Response to Planning Application

From: Arun District Council Greenspace

Application ref: BN/147/21/OUT

Location: Land West of Fontwell Avenue Fontwell Eastergate PO20 3RX

Illustrative Landscape Masterplan (Produced by Fabrik, Nov 2021)

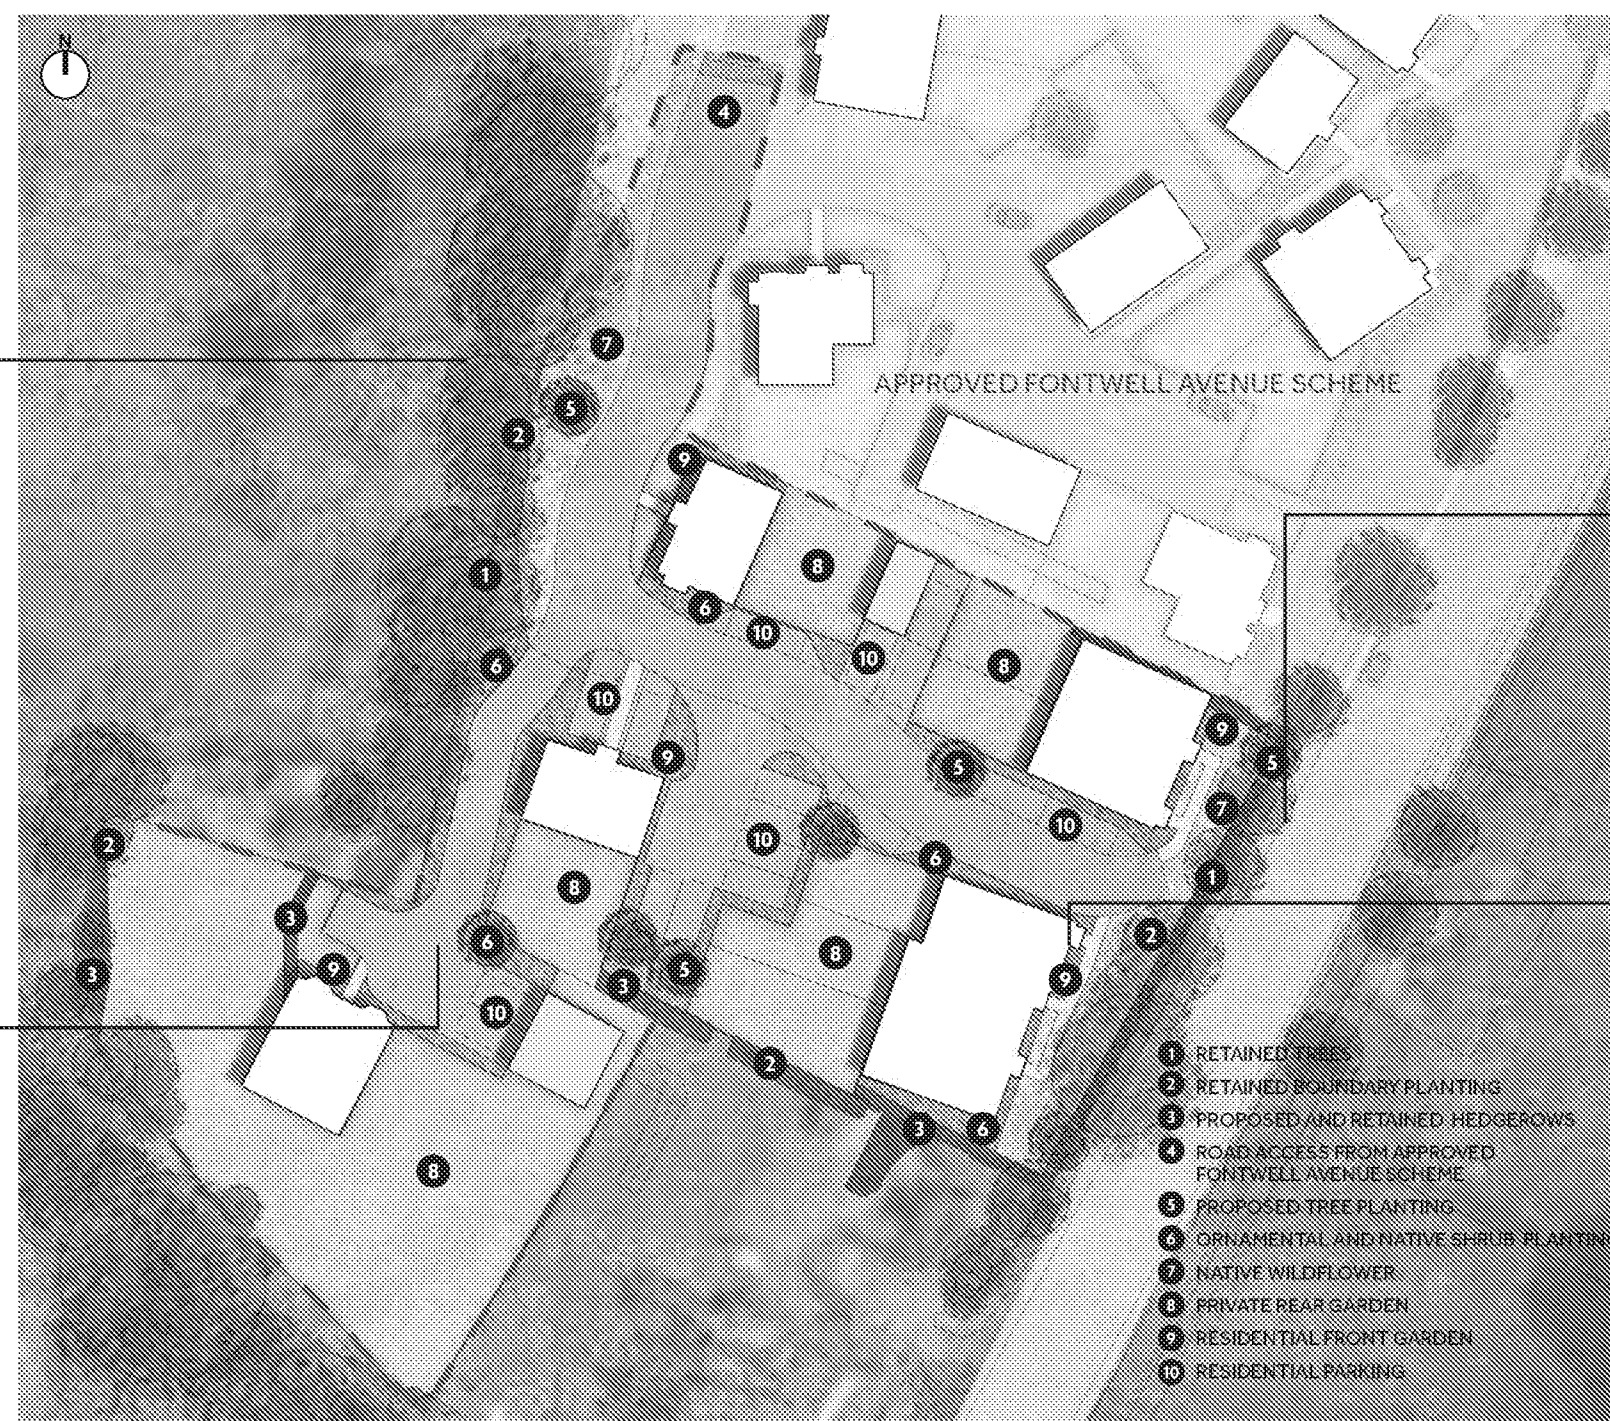
Consideration of existing trees and hedges within the site would be required and any removals agreed with Arun District Councils Tree Officer. Significant hedgerows and trees to the periphery are evident and may be under threat with the road connection to the development to the north. Existing vegetation to the perimeter of these proposals may conflict with private gardens and come under pressure to be removed or pruned. It is good to see that the indicated green buffer shown to the boundaries of this development would go some way to accommodate existing trees and allow for their retention.

An existing green boundary is evident in places, this may require further boundary planting treatment to enhance and improve. Further landscaping would be required within the development and buffer areas to increase biodiversity net gain and habitat within this rural site.

A full and detailed landscape scheme will be required to be submitted for approval, detailing species choice, position, densities and size at time of planting. This should be plotted in plan and list form and in relation to the trees and vegetation to be retained so that a clear picture of the proposals can be seen. These details are required to ensure that appropriate screening is provided, maintaining and uncompromising the setting and ensuring that the proposals fit within the area of neighbouring properties, providing screening as required, increasing biodiversity and wildlife habitat.
